DEVELOPMENT REVIEW BOARD – SPEED MEMO					
	DRB CASE NO/PROJECT NO: 1005317			AGENDA ITEM NO: 8		
	SUBJECT:					
	Site Plan for Subdivision Building Permit					
	ACTION REQUESTED:					
	REV/CMT: ()	APPROVAL: (X)	SIGN-OFF: ()	EXTN: ()	AMEND: ()	
	ENGINEERING CO	DMMENTS:				
	No adverse comment	S.	•			
P.O. Box 1293						
Albuquerque						
New Mexico 87103						
www.cabq.gov						
			•			
	RESOLUTION:					
	APPROVED K; DE	NIED; DEFERRE	D; COMMEN	TTS PROVIDED; V	VITHDRAWN	
	DELEGATED: (SE	C-PLN) (SP-SUB) (S	P-BP) (FP) TO	: (UD) (CE) (TRAN	S) (PRKS) (PLNG

Project # 1005317 / 07EPC 00011 – COA Water Utility Dept.

Re: Project # 1005317/07EPC-00011 EPC Site Development Plan for Building Permit for new Pump Station near Forest Hills Drive on Presbyterian property

FILE: Project # 1005317*
07EPC-00011 EPC Site Development Plan-Building Permit

1 NORTH ELEVATION
SCALE: 1/4"=1'-0"

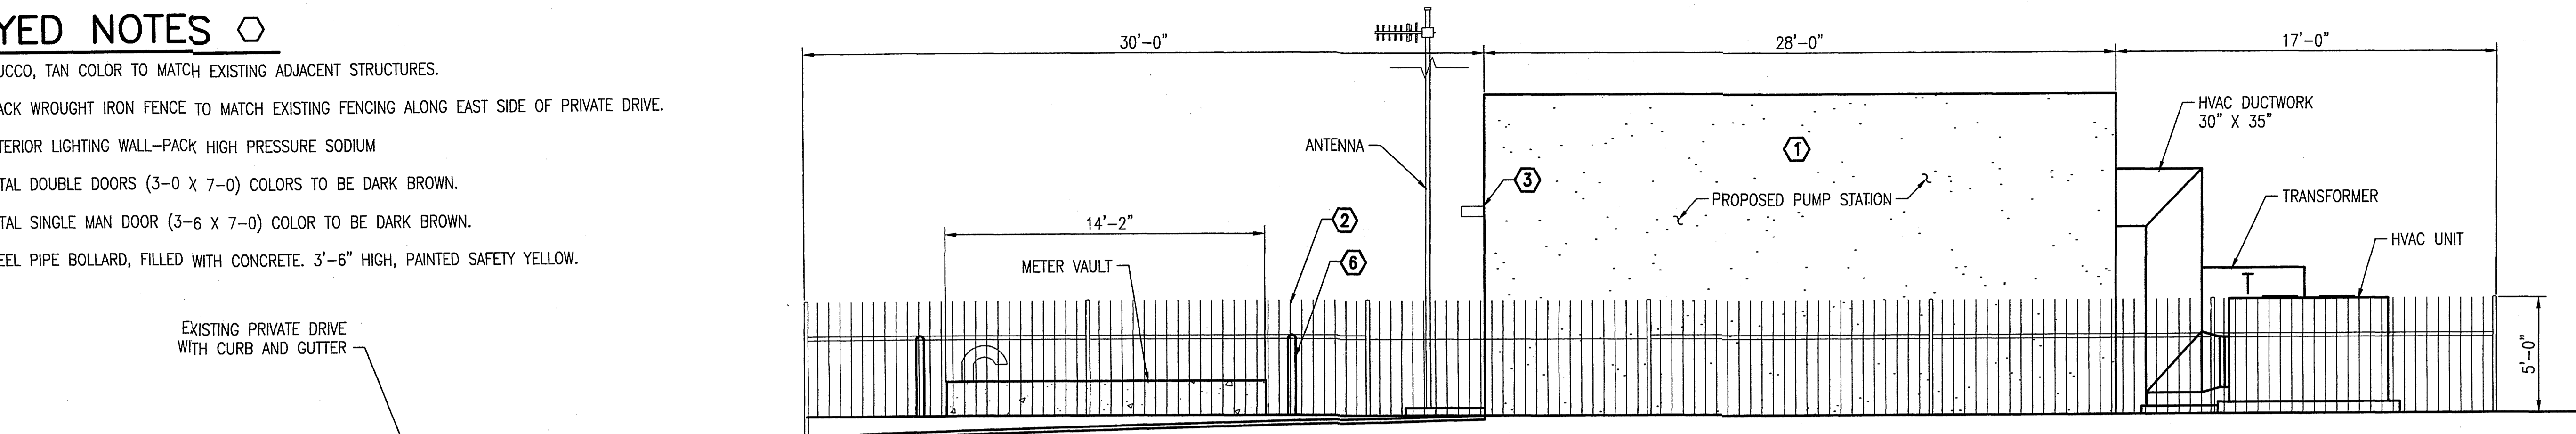
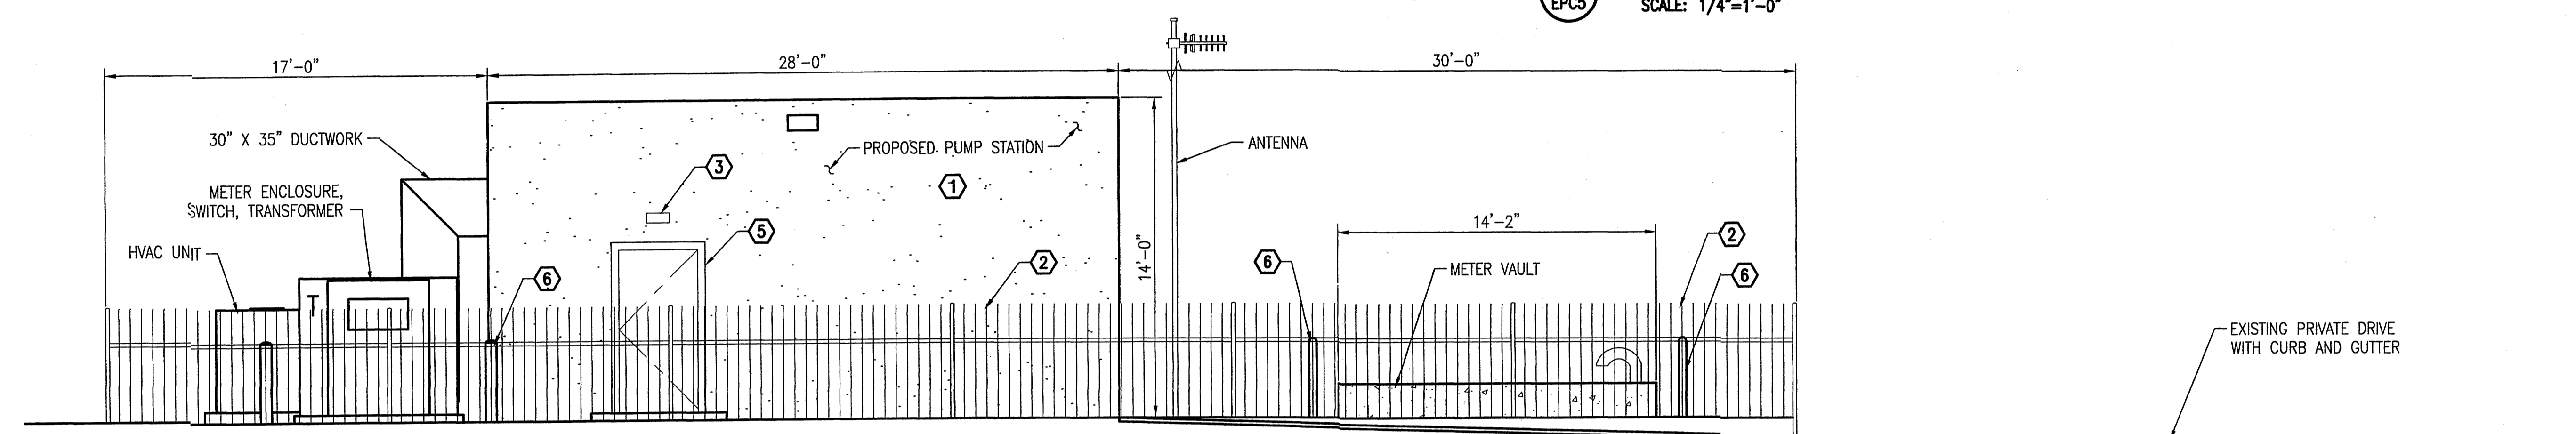
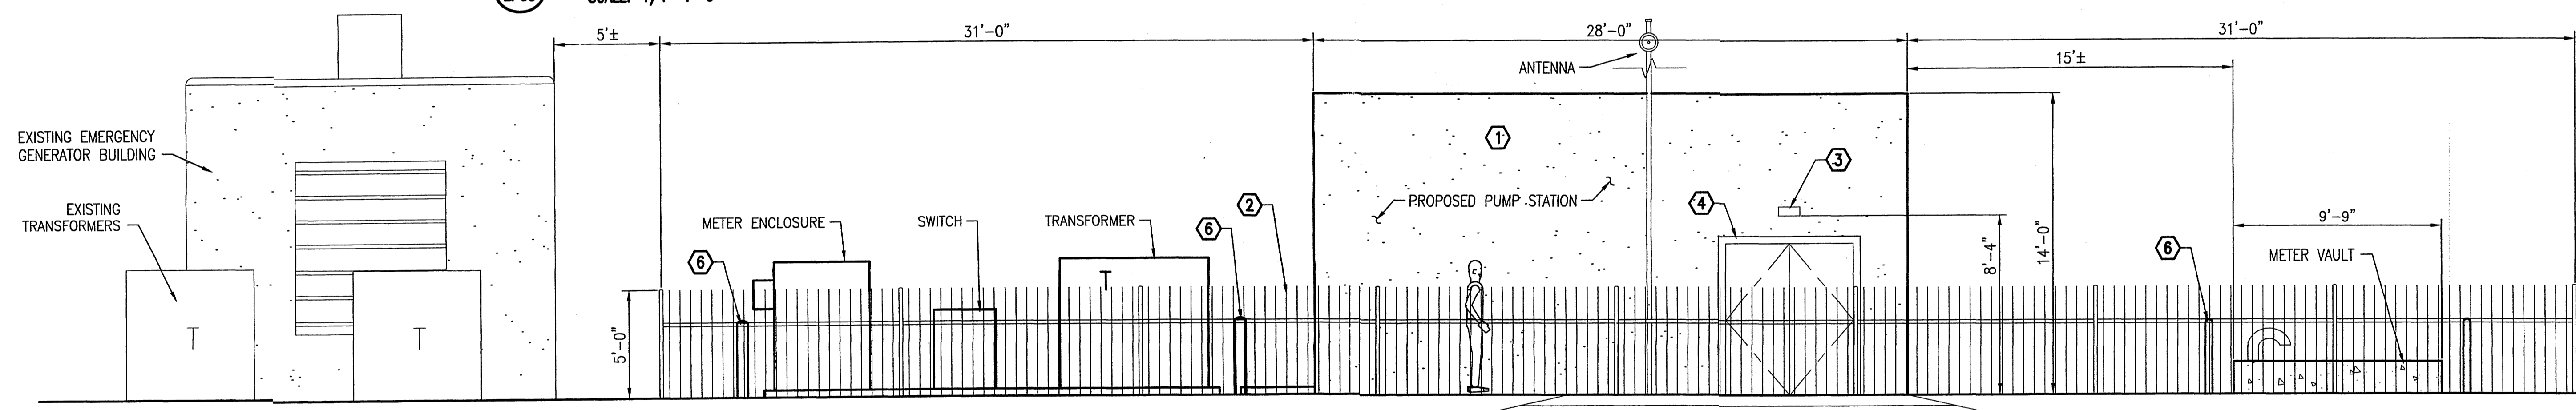
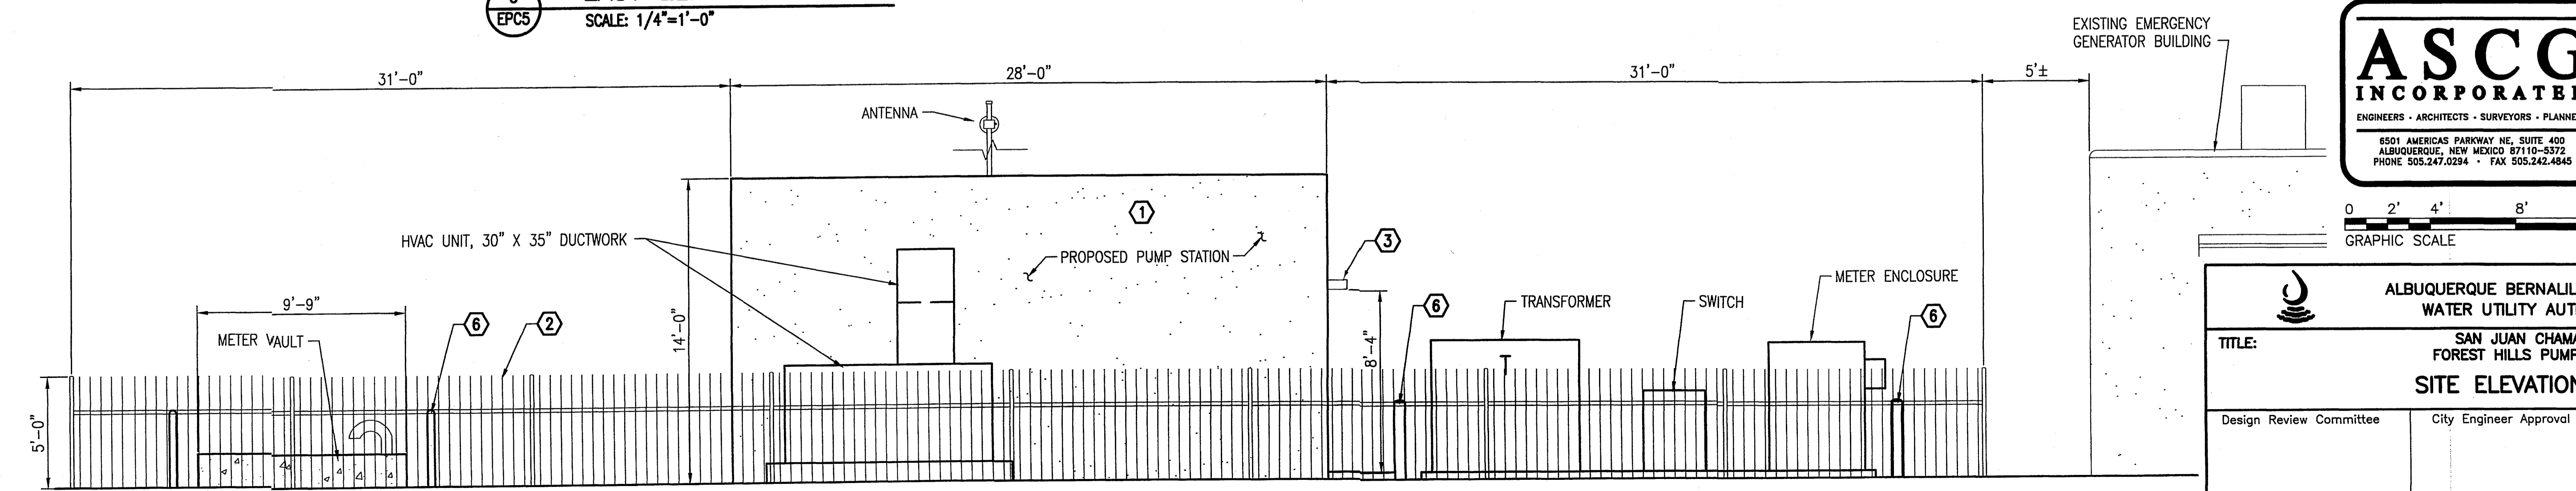
- a. Re. Note 2, replace 'on site' with 'along east side of private drive'.
 - b. Re. Notes 4 & 5, specify the material of the doors.
 - c. Key bollards around outdoor equipment and indicate material and color.

- a. Re. Note 2, 'on site' has been replaced with 'along east side of private drive.'
 - b. Notes 4 & 5 now specify the material of the doors to be metal.

- c. Steel pipe bollards around outdoor equipment have been identified and are called out as "Painted Safety Yellow."
